Memo

To: Samantha Gatchene, MCIP, RPP
From: Angela Mariani
cc: Peter Gregor
Date: June 20, 2023
Re: Parking spaces Wellings of Stittsville Phases 2 and 3

SP-00

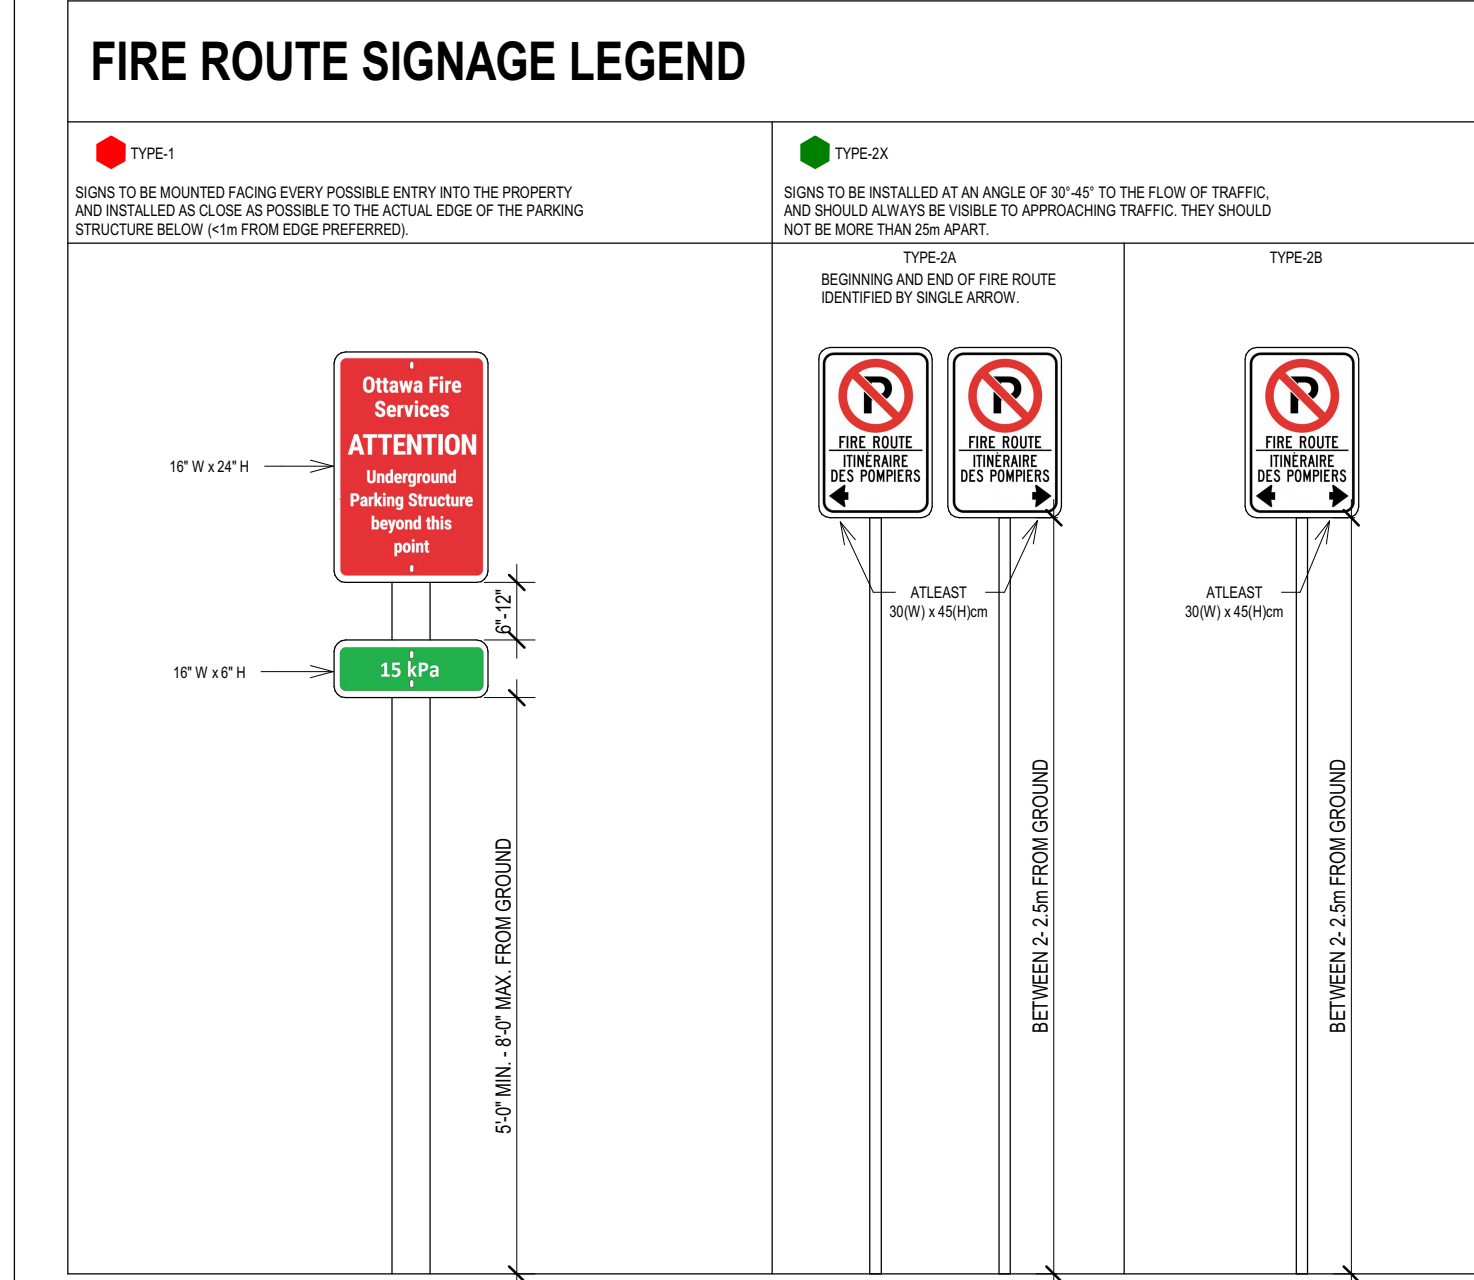
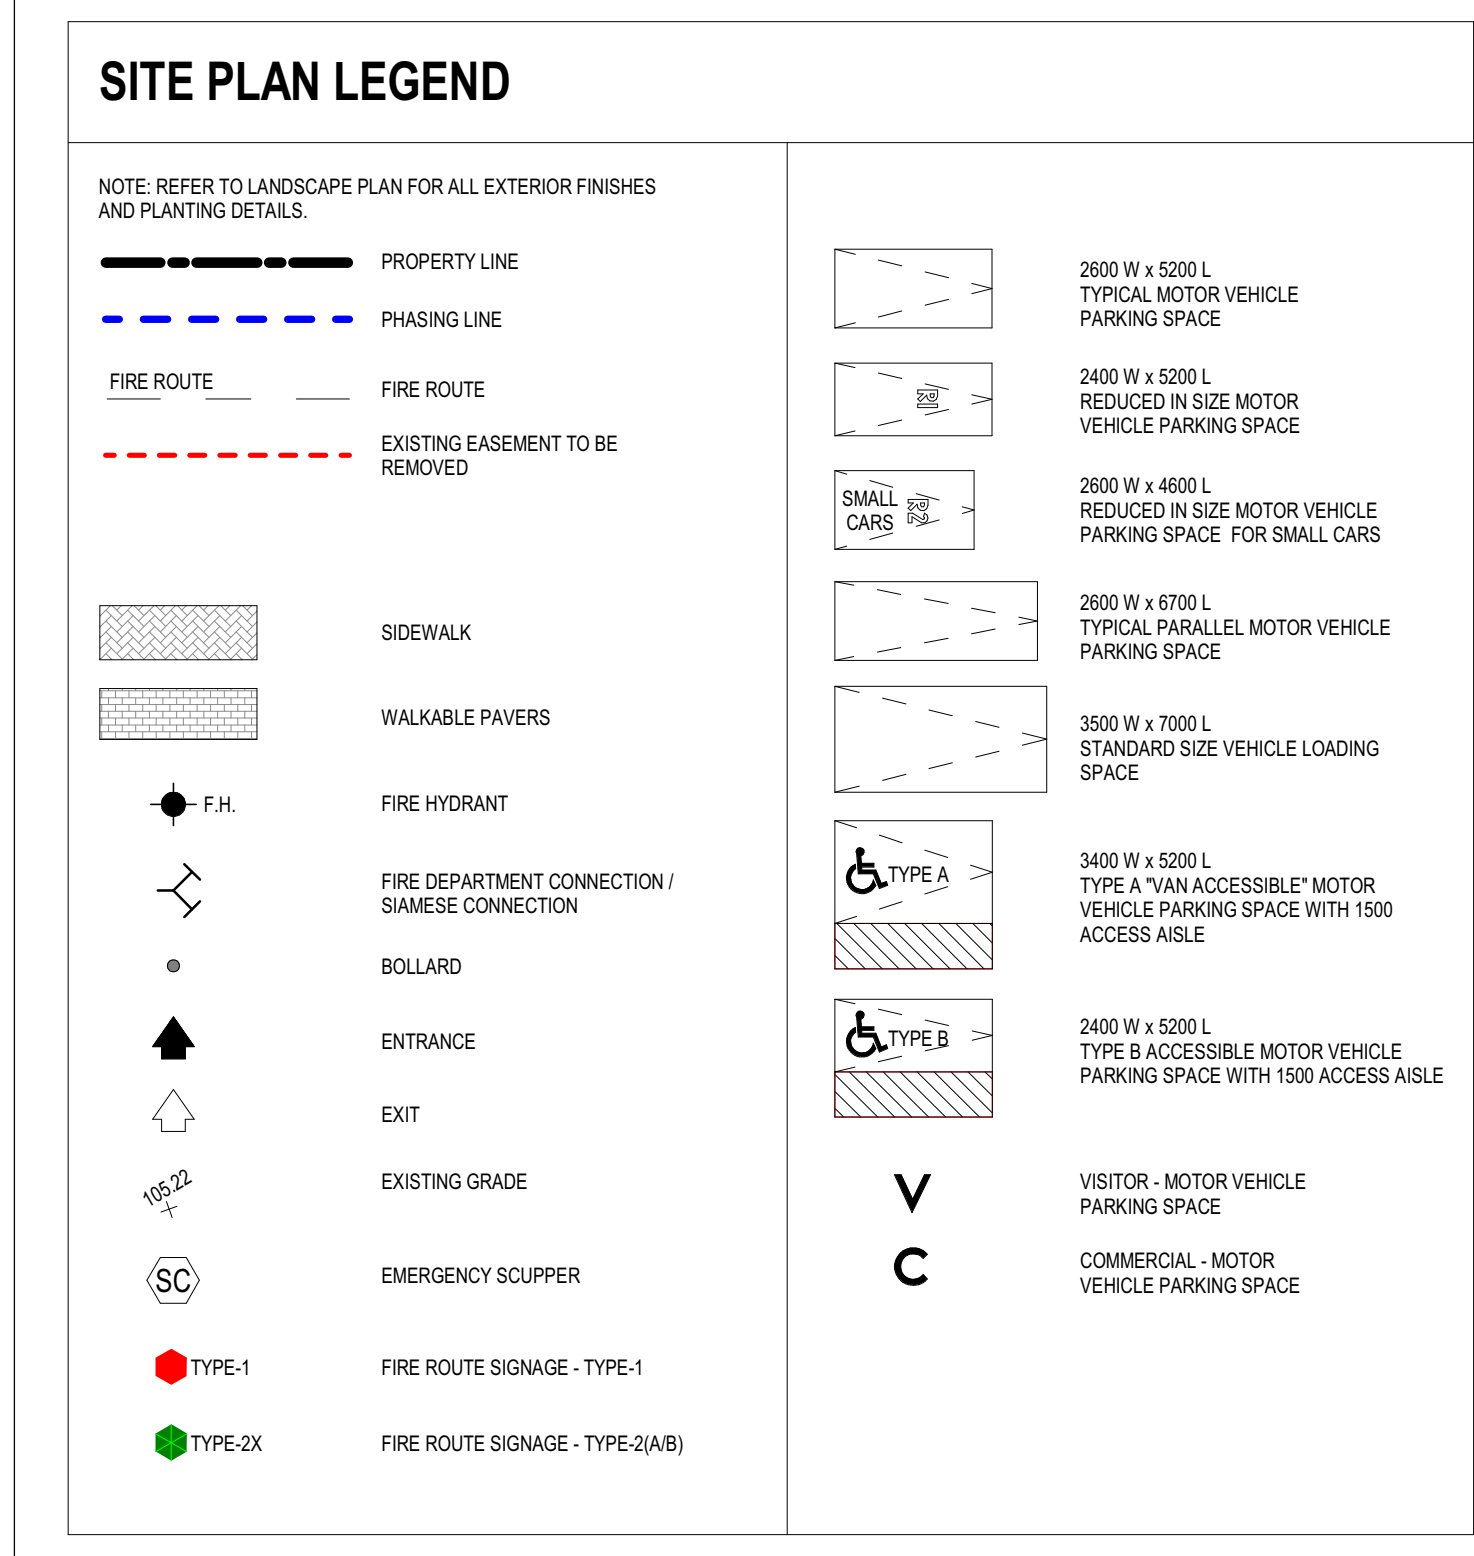
In response to the comment regarding the excess of parking spaces provided for Wellings of Stittsville Phases 2 and 3, the required parking spaces for residents in the zoning by-law is calculated at a rate of 0.25 spaces/dwelling unit for seniors residential. The Wellings is an independent senior's residential development. This is a 55+ community with a number of residents still owning cars, some residents continue to work, and others drive to friends and family and to and from appointments.

In review of the actual car ownership in Wellings of Stittsville Phase 1, 65-70% of the residents own cars. With 238 parking spaces being provided (201 below grade and 37 above grade), this number would serve to meet the needs of the residents.

The proposed parking spaces were well thought out and with consideration to the actual parking needs of the Phase 1 building. Also provided are spaces for commercial, though the principal usage of the services will be by the residents. Visitor parking has also been included as well as some spaces for the staff parking needs.
